REQUEST

Current Zoning: R-3 (single family residential)
Proposed Zoning: R-8MF(CD) (multi-family residential, conditional)

Approximately 2.46 acres located on the north side of Johnston Oehler Road and south side of Interstate 485, west of Mallard Creek Road.

PLANNING STAFF REVIEW

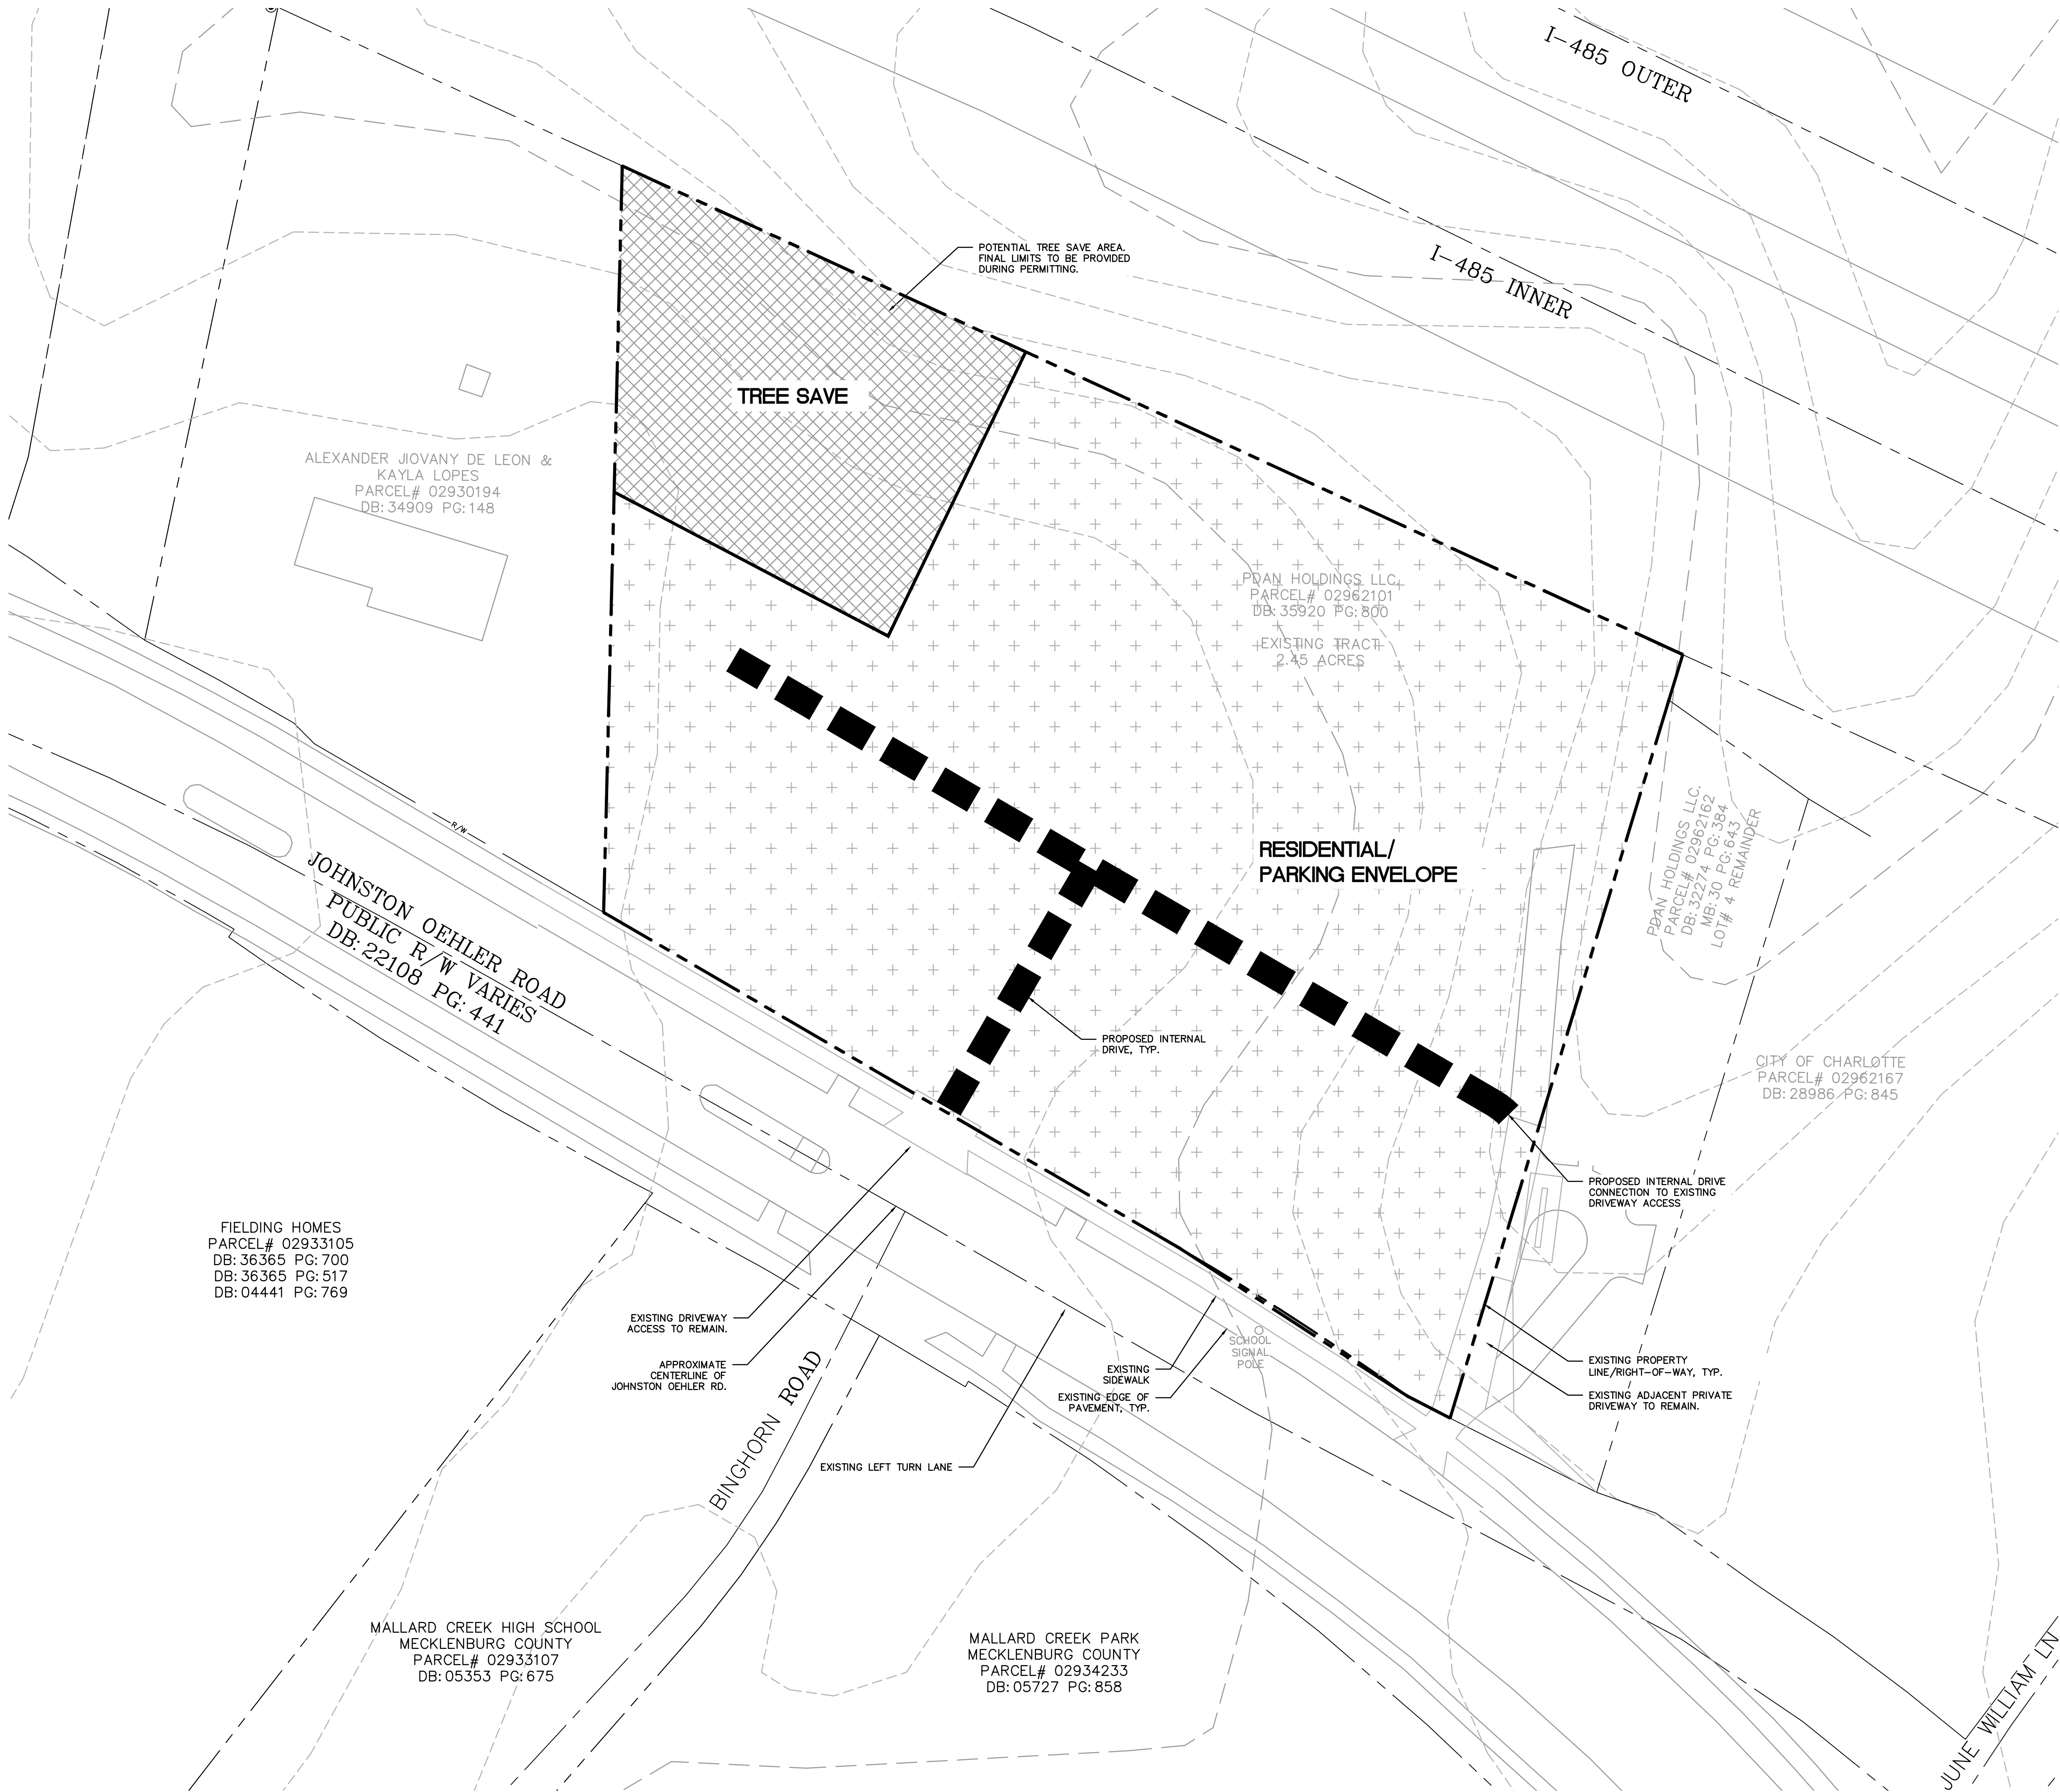
1. Part of what is shown would not qualify as protected tree save. This will either need to be adjusted to protect existing trees and/or additional tree save would be required.

2. Please clearly specify unit type (single family detached, single family attached townhomes, or multi-family) on the site plan. Please ensure all notes and data are consistent with respect to type and unit count on all sheets.
3. Under Permitted Uses Heading, remove detached if a multi-family use is proposed. If a detached use is proposed all lots must front on a public street. Also provide acreage and lot dimensions for all lots for a detached use. Please ensure all sheets are consistent with respect to information.
4. Increase setback to 30 feet along Johnston Oehler Road and along I-485.
5. Connect buildings to sidewalk system along Johnston Oehler Road.
6. Illustrate parking on site plan.
